EP-24-0077 Monument Ridge East
N½ Section 2, T11S, R67W, 6th Meridian
39.1284, -104.8624
File Number: SP241

With this referral, we received a request to provide Review Comments (Email dated 8/29/2024), Preliminary Drainage Report (PRC Engineering, 9/5/2024), Preliminary Plan Drawings (Bear Creek Surveying, Inc., 8/12/2024), Response to Review Comments and Soil and Geology Study (Revised) (Entech Engineering, Inc., 8/7/2024), and other documents. Entech updated Figure 7 (Geology/Engineering Geology Map) to the current site plan with the geologic hazards and constraints associated with the site. Additionally, the preliminary plan has been updated to reflect Entech's study.

PROPOSED GRADING PLAN
MONUMENT RIDGE EAST
MONUMENT HILL ROAD & PALMER DIVIDE ROAD
EL PASO COUNTY, CO.
FOR: MONUMENT RIDGE EAST, LLC

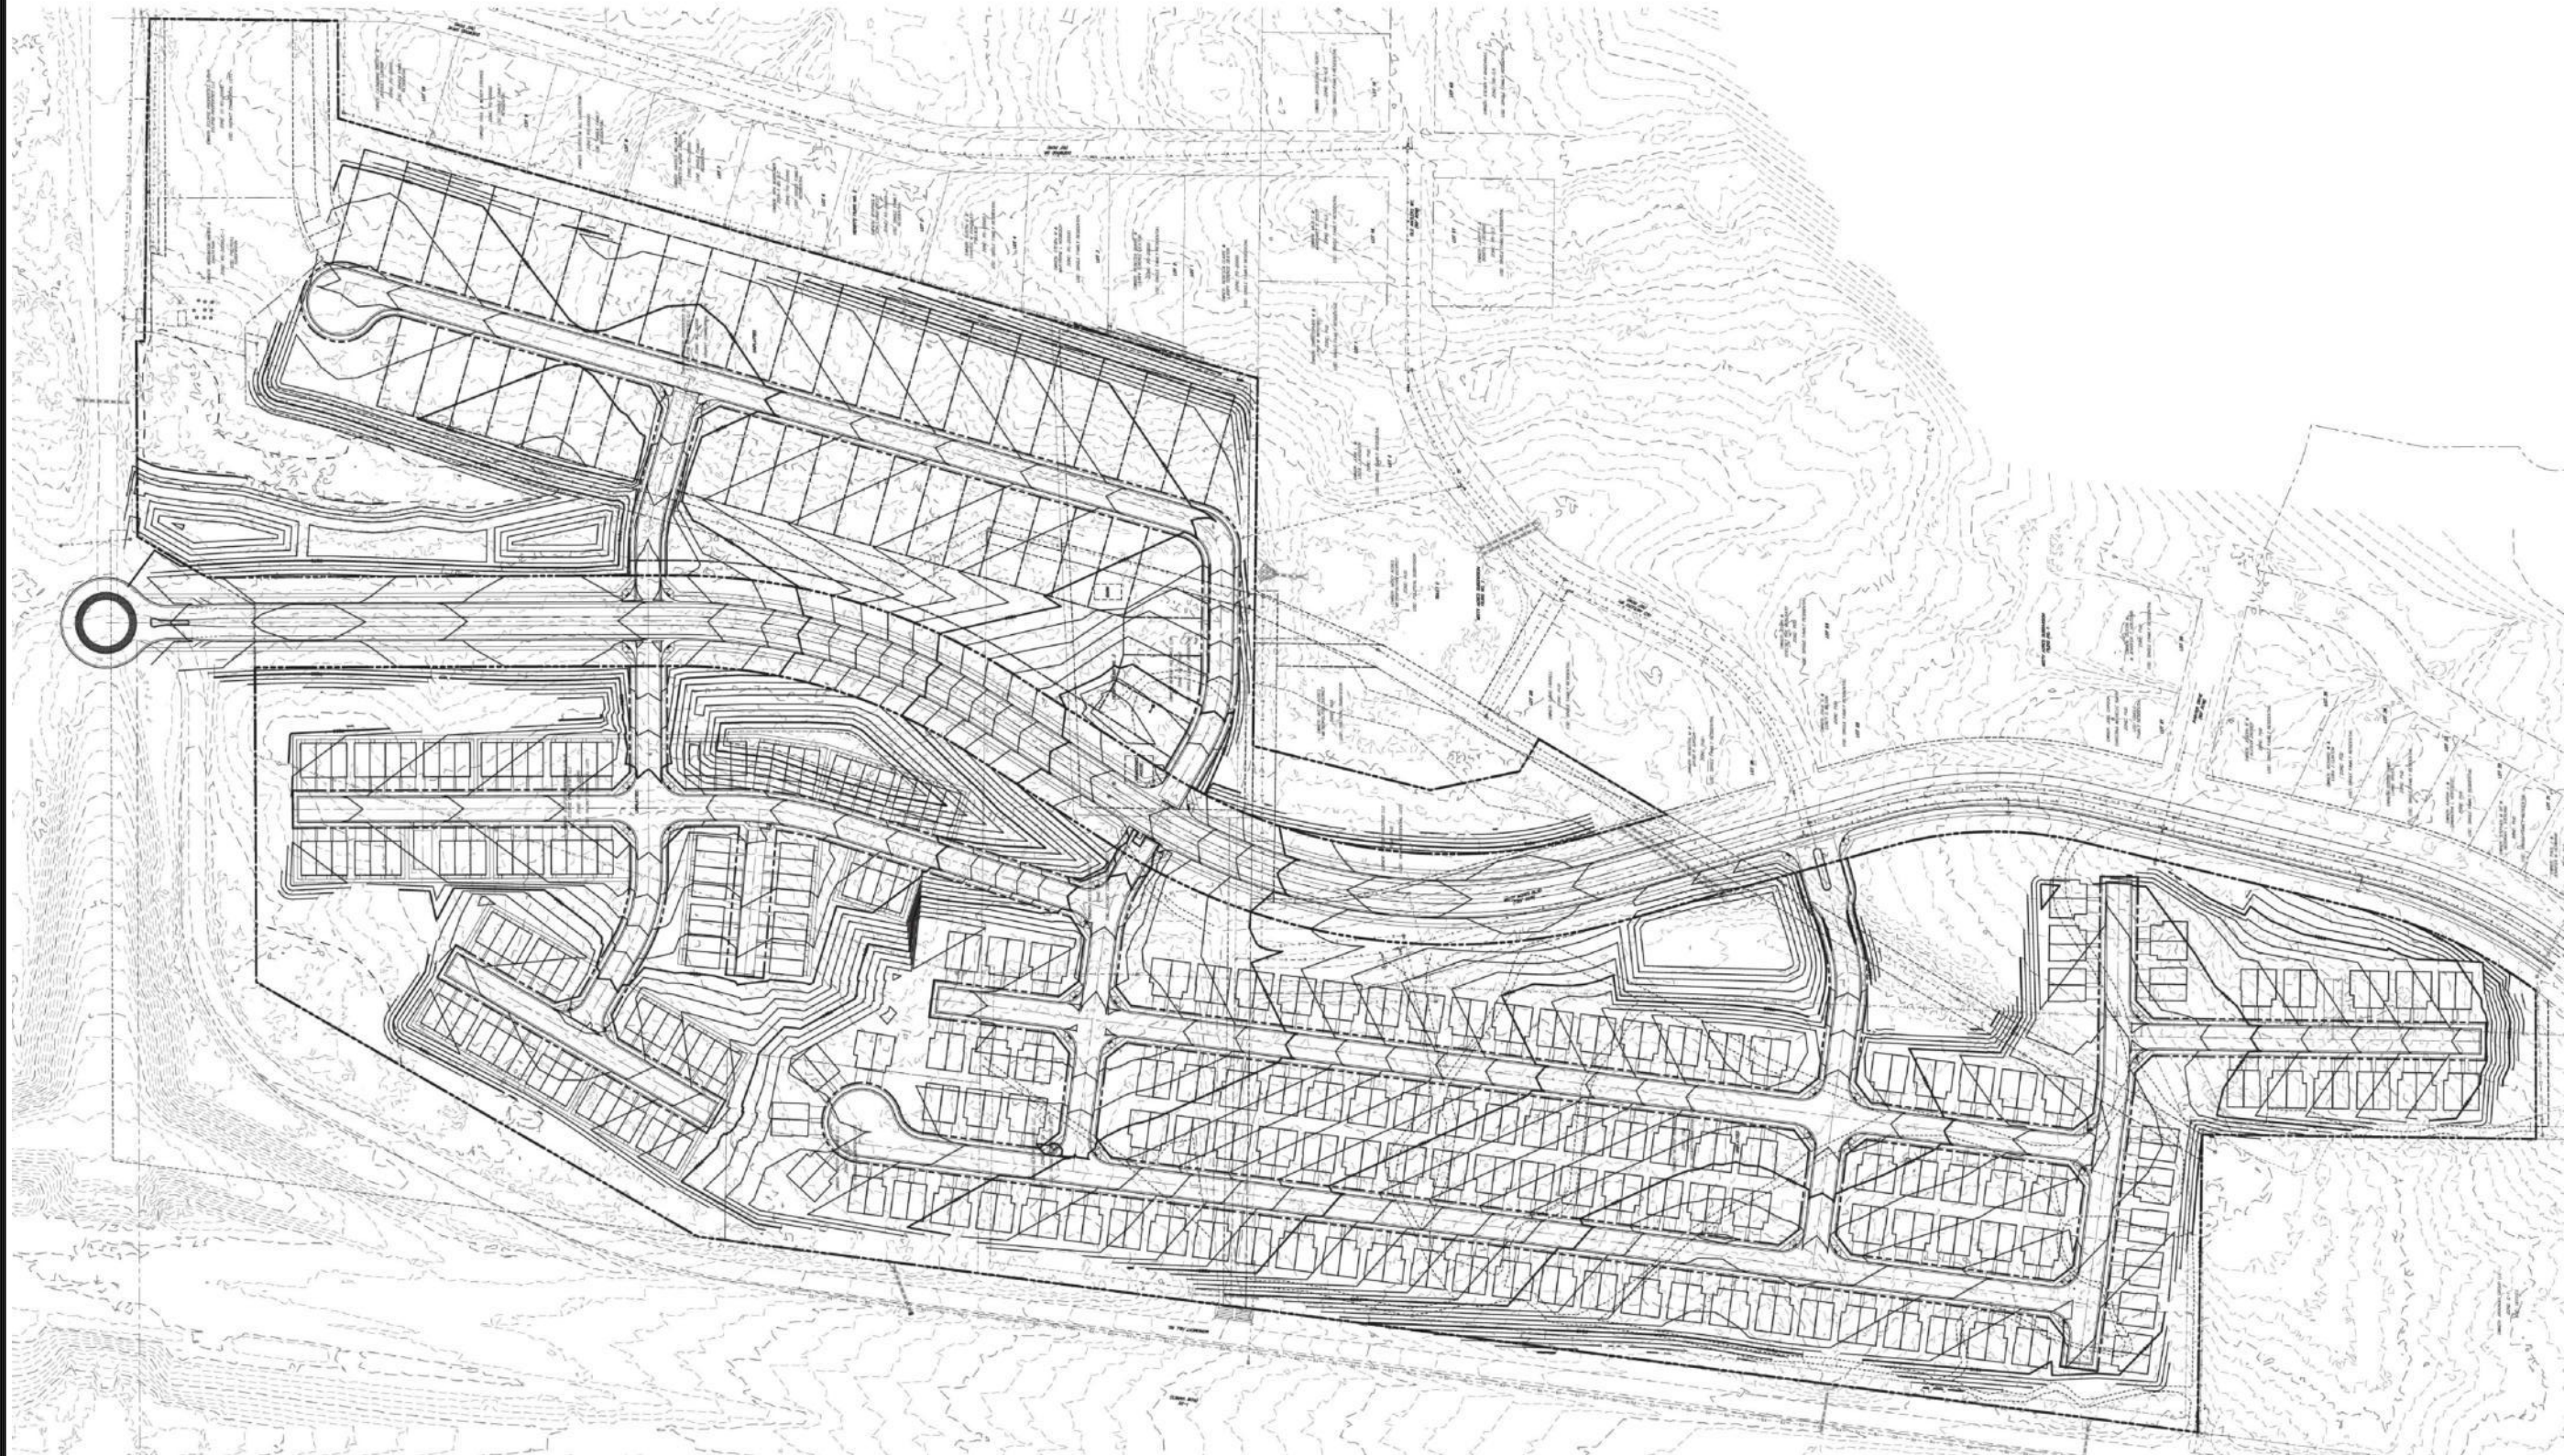
1. Entech states in the response letter (page 1), *“The proposed grading indicates significant cuts of up to 20 to 24 feet across the site. Four piezometers were recently installed in areas of proposed cuts and where shallow water conditions were previously encountered in Test Boring Nos. 1 – 4.”*
